**Consultation Response from KC,  
Highways Development Management**

**2025/93423 2, Brewery Yard, Fenay Bridge, Huddersfield, HD8 0AR**

**Demolition of existing dwelling and erection of detached dwelling**

**Date Responded: 31/03/2026**

Site Plan
1 : 200

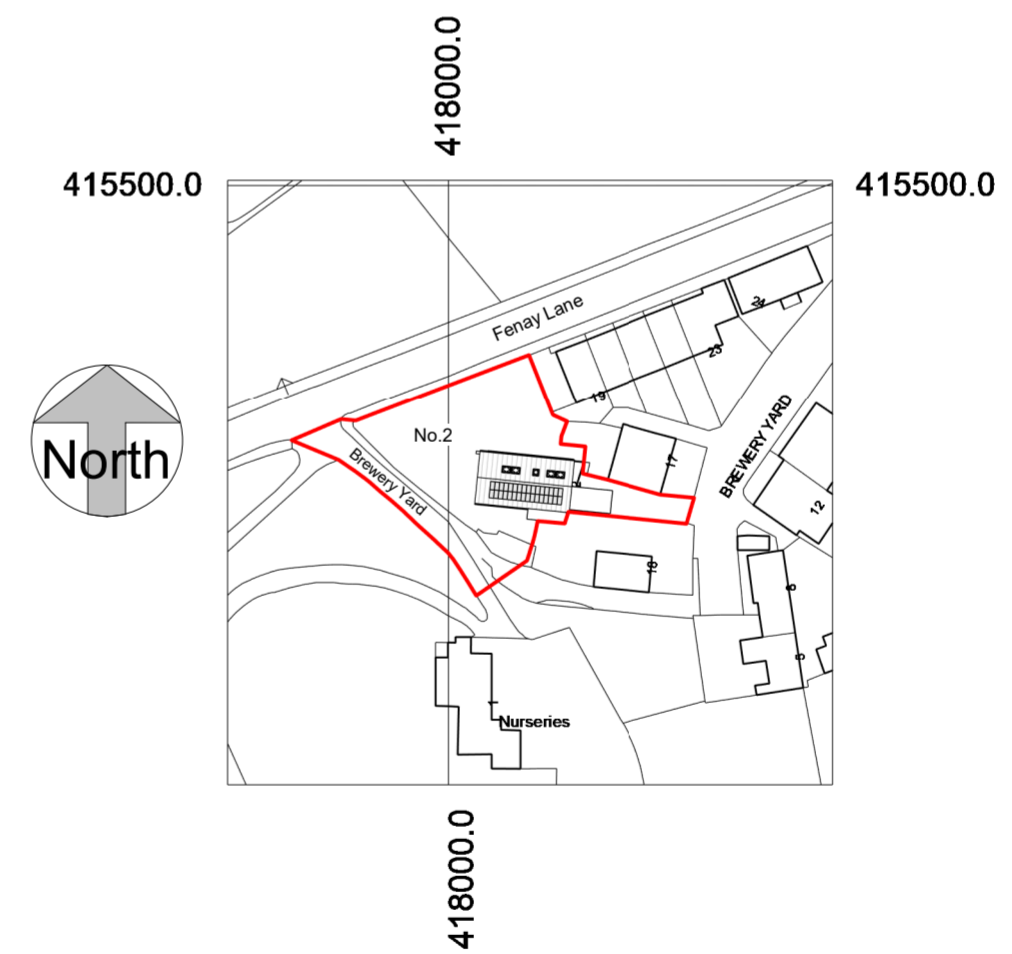
Given that this is a replacement dwelling and sufficient off-street parking is shown to be retained Highways Development Management have no objection to these proposals.

The approved vehicle parking areas will need to be surfaced and drained in accordance with the Communities and Local Government; and Environment Agencies 'Guidance on the permeable surfacing of front gardens (parking areas)' published 13th May 2009 (ISBN 9781409804864) as amended or superseded.

No bin store and/or bin collection/presentation is shown on the proposed plans.

A bin collection/presentation point should be located adjacent to the public highway and must not obstruct the adopted highway or the parking spaces.

Details of the waste collection for the proposed dwelling should be provided, with the location of a waste collection presentation point being clearly marked on a drawing in such a location that is easily accessible to the collection team and where it will not obstruct the access or the adopted highway for road safety reasons.
